**UKWIN'S D4 COMMENTS
ON REP3-022 & REP3-040**

(REP3-022: NLGEPL'S D3 COMMENTS ON UKWIN'S D2 WR AND
D2 COMMENTS ON THE RDF SUPPLY ASSESSMENT REV 1,
& REP3-040: RDF SUPPLY ASSESSMENT REVISION 2)

North Lincolnshire Green Energy Park

EN010116

**Figure 9 – Treatment capacity in England (kte)**

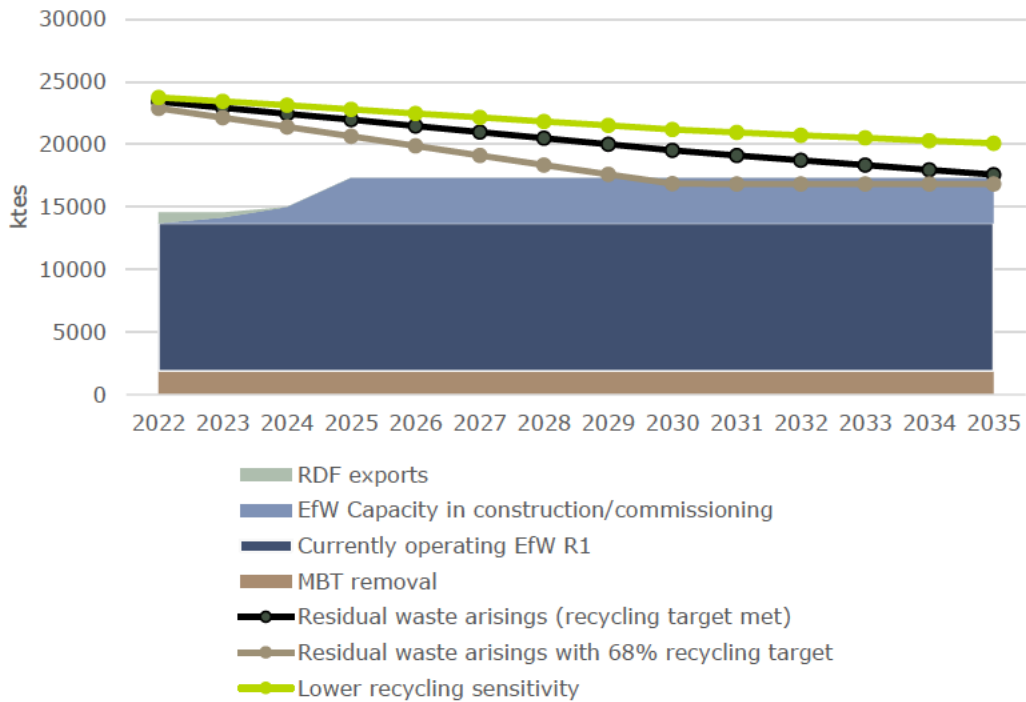
36. It is notable that REP3-040 Figure 9 shows that with a recycling rate of 68% (depicted as a brown line), currently operational R1 EfW capacity combined with capacity that is currently under construction or in commissioning exceeds the quantity of residual waste arising by 2029/30 (without inclusion of the proposed North Lincolnshire capacity). This indicates that there is no national (English) 'capacity gap' to fill.

38. Figures 9 and 10 do not include:

- a) 595ktpa of capacity at Rivenhall (which is outside the region but relevant to national EfW capacity)
- b) Co-incineration capacity, e.g. cement kilns
- c) The impact of halving residual waste per capita by 2042 and the Government's associated interim targets (as set out in the Environmental Improvement Plan 2023)
- d) The full capacity for some of the incinerators on their list
- e) Non-R1 EfW capacity
- f) Aging capacity that could be refurbished (e.g. Stoke, Coventry)
- g) Waste that can be expected to be used to meet the Government's Jet Zero Strategy (for the production of Sustainable Aviation Fuel)

39. As such, the fact that the Applicant's own evidence shows that the proposed North Lincolnshire incinerator appears not to be needed even before the above-listed matters are taken into account should be given significant weight.

**Figure 10 – Treatment capacity in Yorkshire & Humber and East Midlands (kte)**

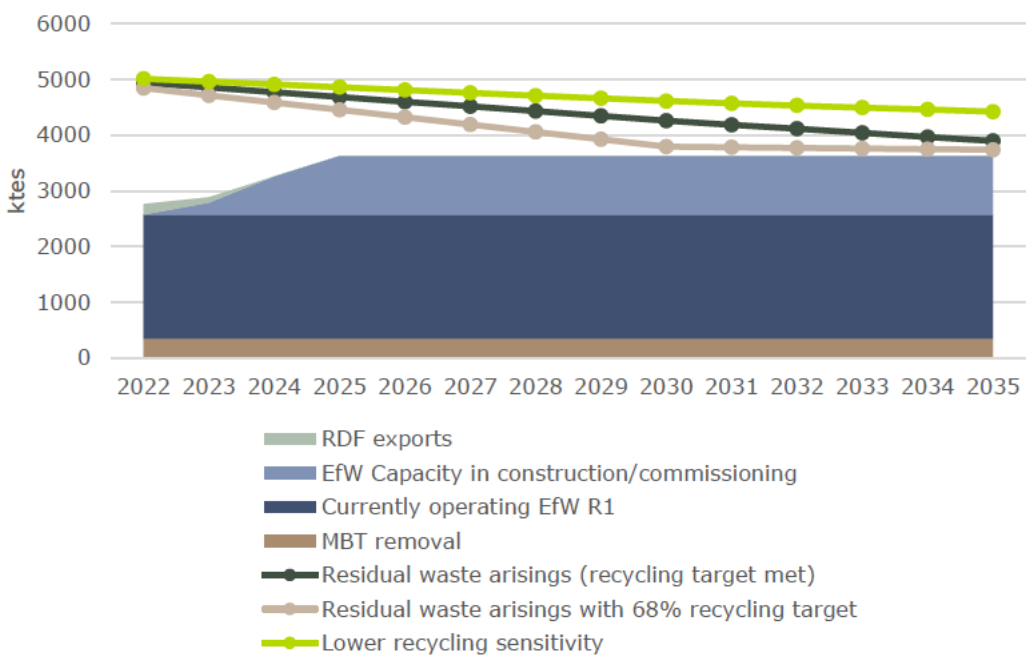
37. REP3-040 Figure 10 indicates that regional capacity of existing R1 EfW facilities in Yorkshire & Humber and the East Midlands is very close to the expected levels of waste arisings in the 65% and 68% recycling scenarios.

49. Given the Applicant's regional capacity forecast set out in Figure 10 of REP3-040, it appears that the North Lincolnshire plant would similarly result in exacerbating regional incineration overcapacity.
50. These levels of overcapacity would be even higher if all of the matters set out in sub-bullet points b-g (above) are considered in line with UKWIN's proposed approach and assumptions.
51. The overcapacity figure would be higher still if it were assumed that some of the consented capacity currently in the pipeline entered construction, e.g. based on the Applicant's assumption that approximately 50% of consented capacity will be realised, as set out on electronic page 134 of REP3-022.
